TO: Dusty Pilkington, Community Development Services  
FROM: Kelly Bacon, Engineer Technician I  
DATE: December 19, 2017 *KB*  
SUBJECT: Teanaway Ridge BL-17-00021

The Public Works Department has reviewed the Request for Boundary Line Adjustment Application. In order to ensure that it meets current Kittitas County Road Standards, the applicant needs to provide the following prior to final approval:

BOUNDARY LINE ADJUSTMENT

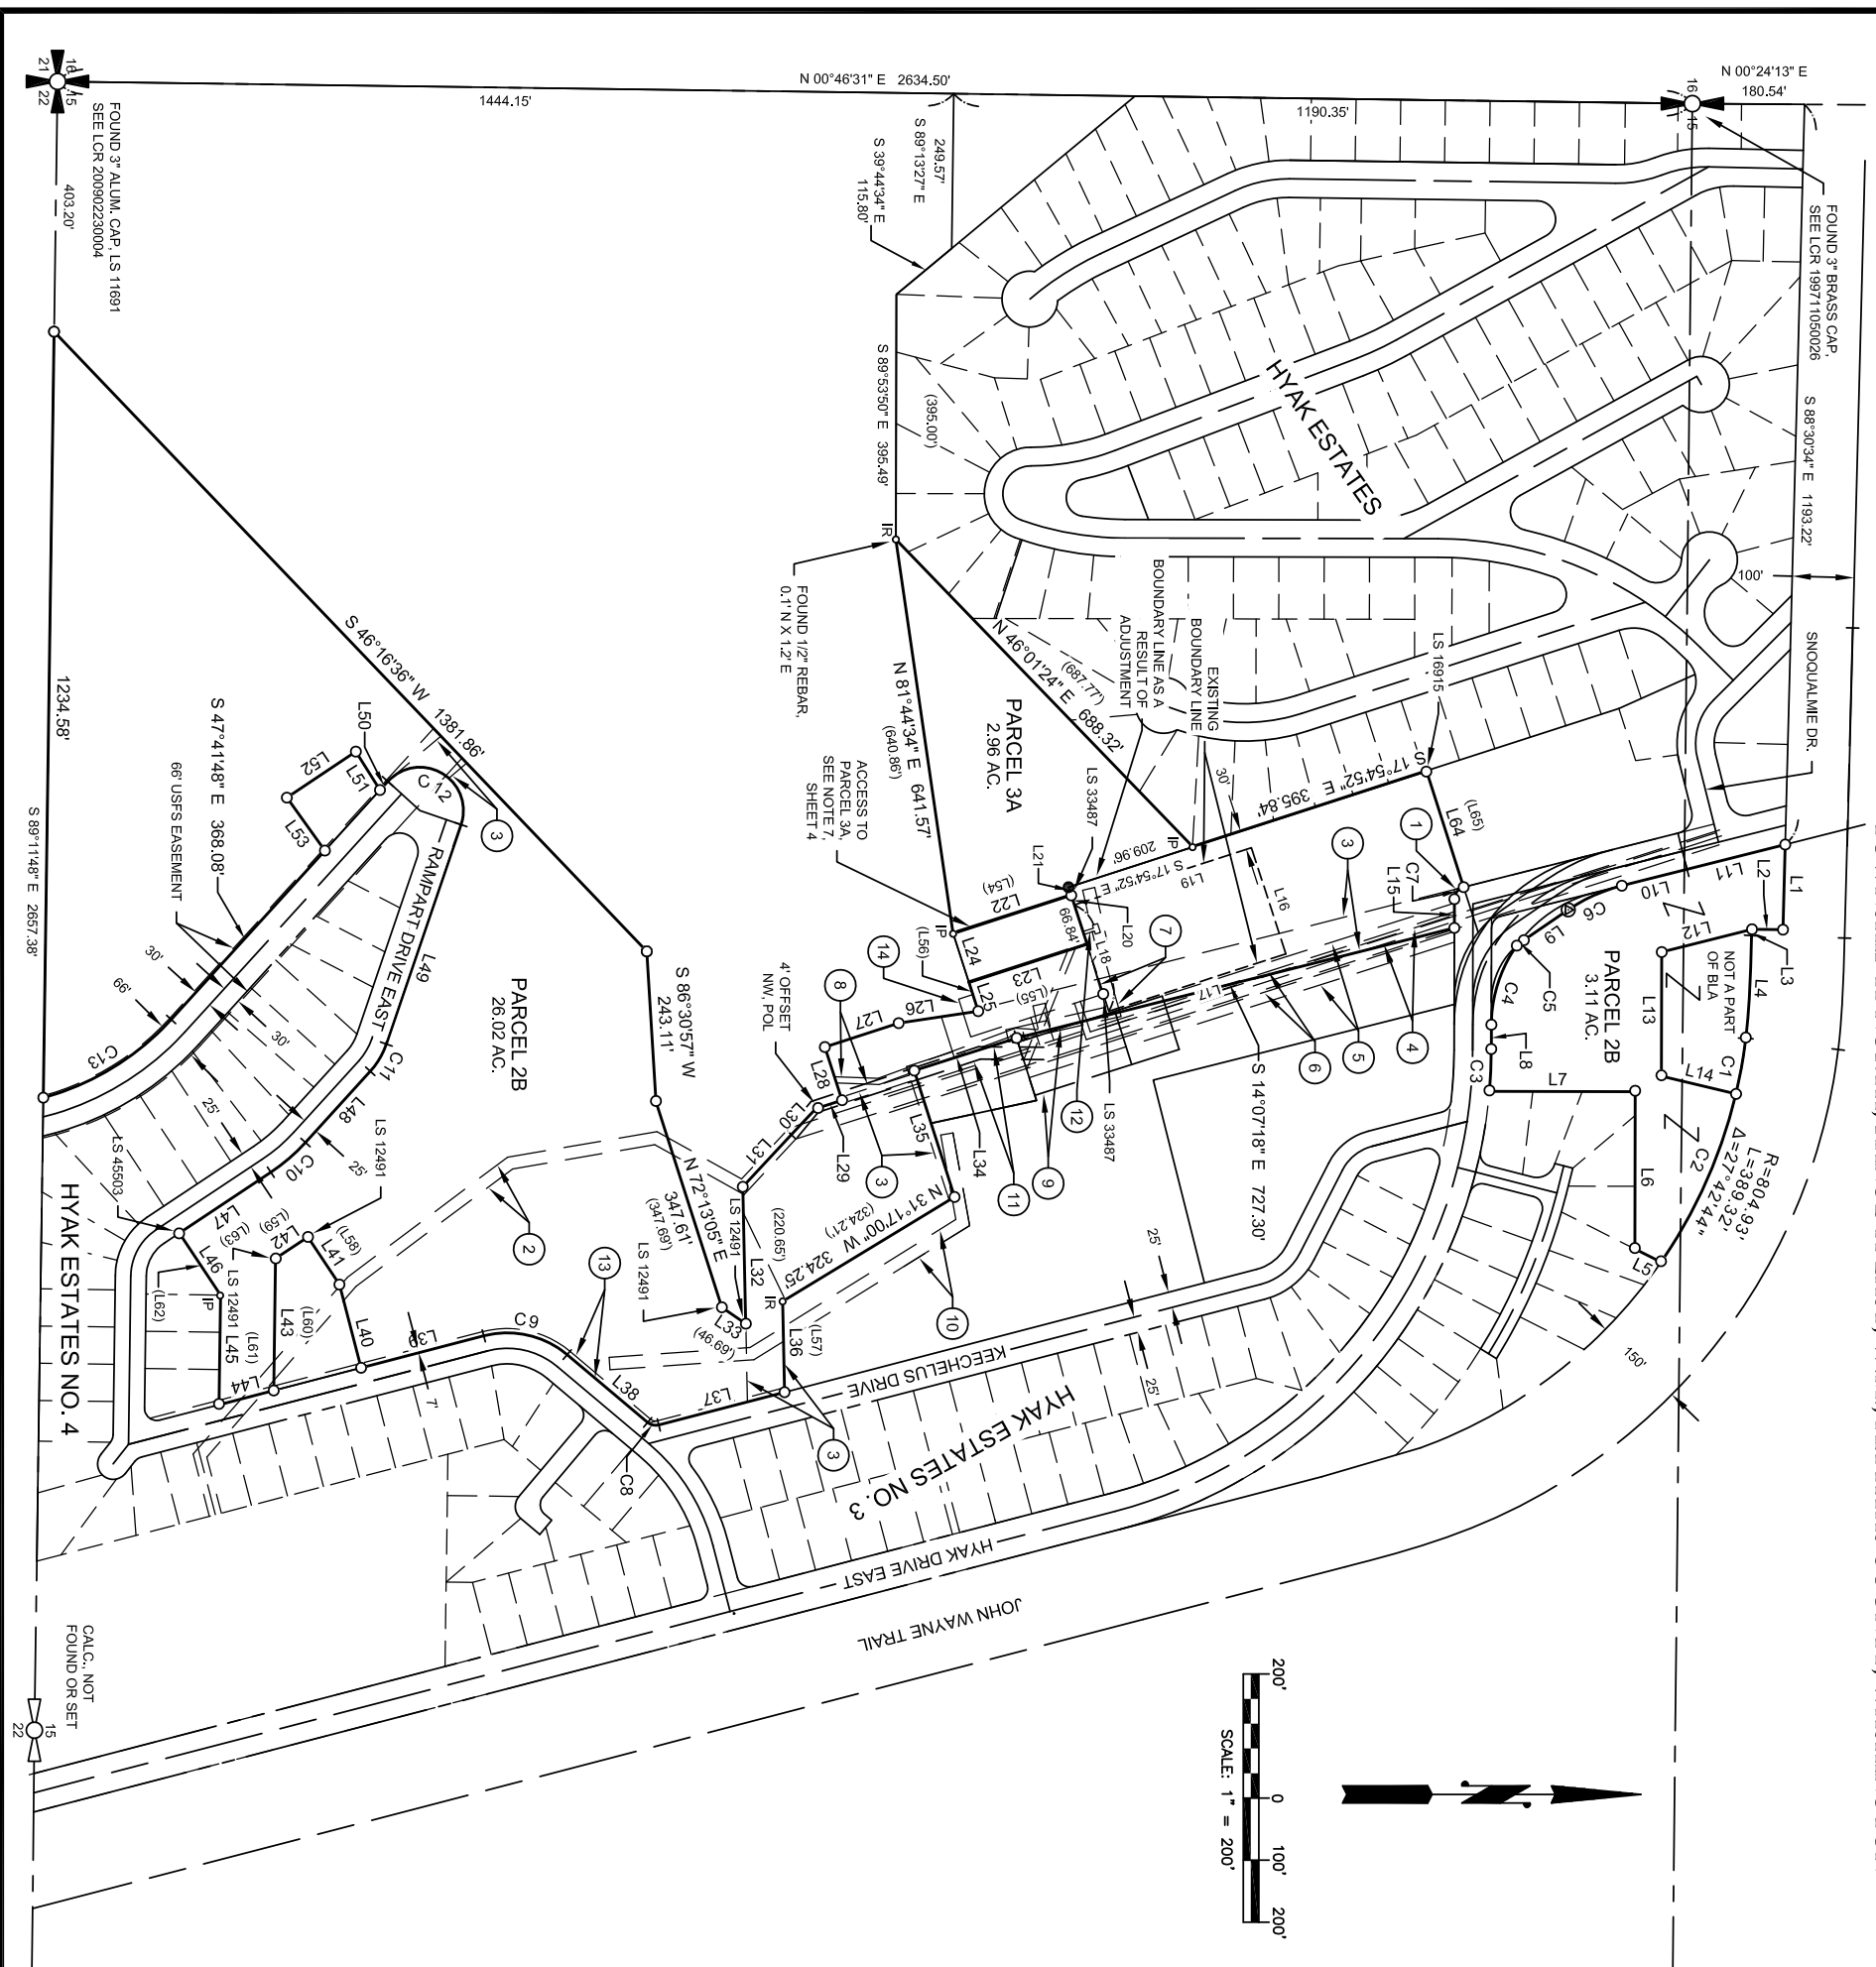
1. A revised legal description that describes the final configuration of the subject property shall be required.
2. Show access easements on the face of the BLA
